From: [Ruth Redding](#)
To: "Kelly "
Subject: RE: Invalid Letter 21/01543/F
Date: 10 August 2021 12:50:16
Attachments: SFRA Proforma.docx

I appreciate that you have an 'extant' permission from 2015, but you are making a brand new application and this must be registered in accordance with the current criteria for validation, regardless of previous applications. In addition, I have clarified with my Principle Planning Officer this morning regarding the Habitat Mitigation Fee who has agreed, as this is a new application, the fee is applicable.

GROUND FLOOR PLAN

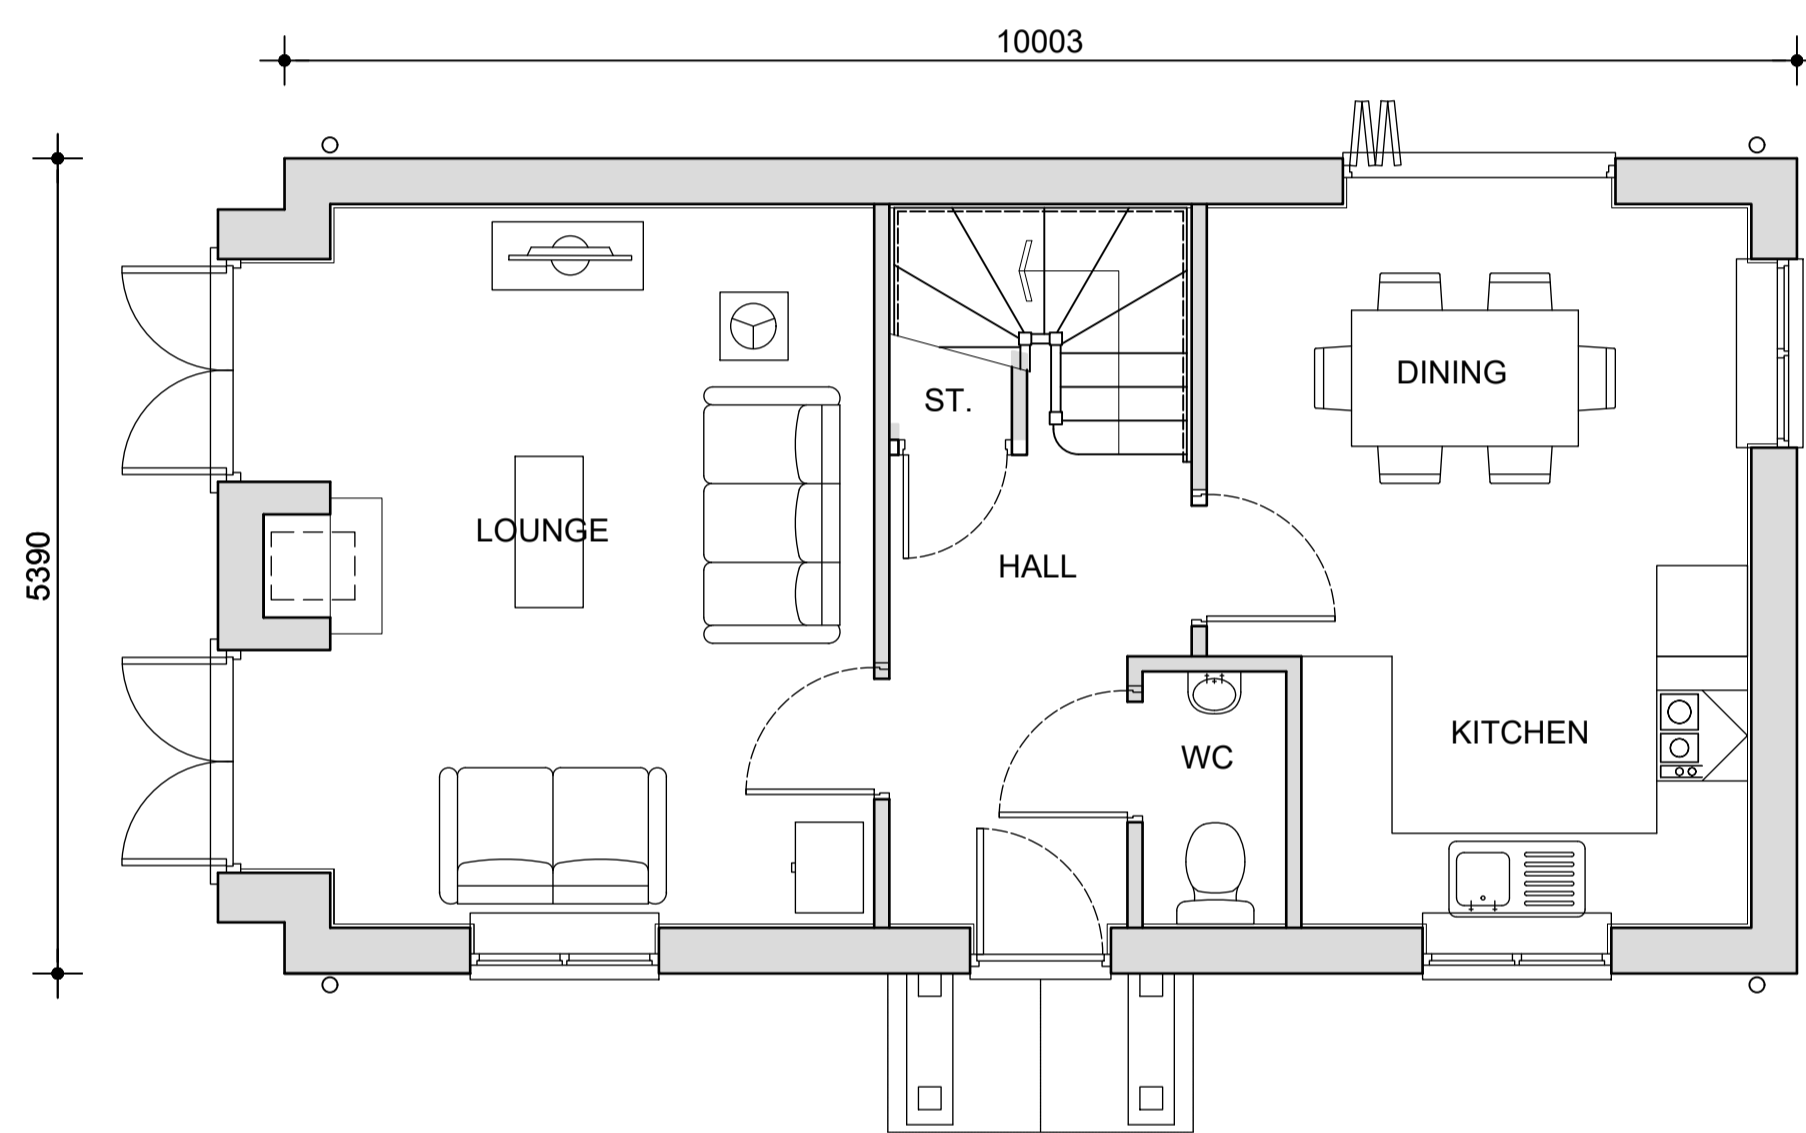
1. Contaminated Land Questionnaire (unfortunately, this wasn't attached to your email as stated?)
2. Habitat Fee (refundable on request, should the application be refused)
3. Flood Risk Matrix (editable version attached).
4. Section-through new dwelling
5. Item 7. On my colleagues email (slight error on the proposed ground floor plan)
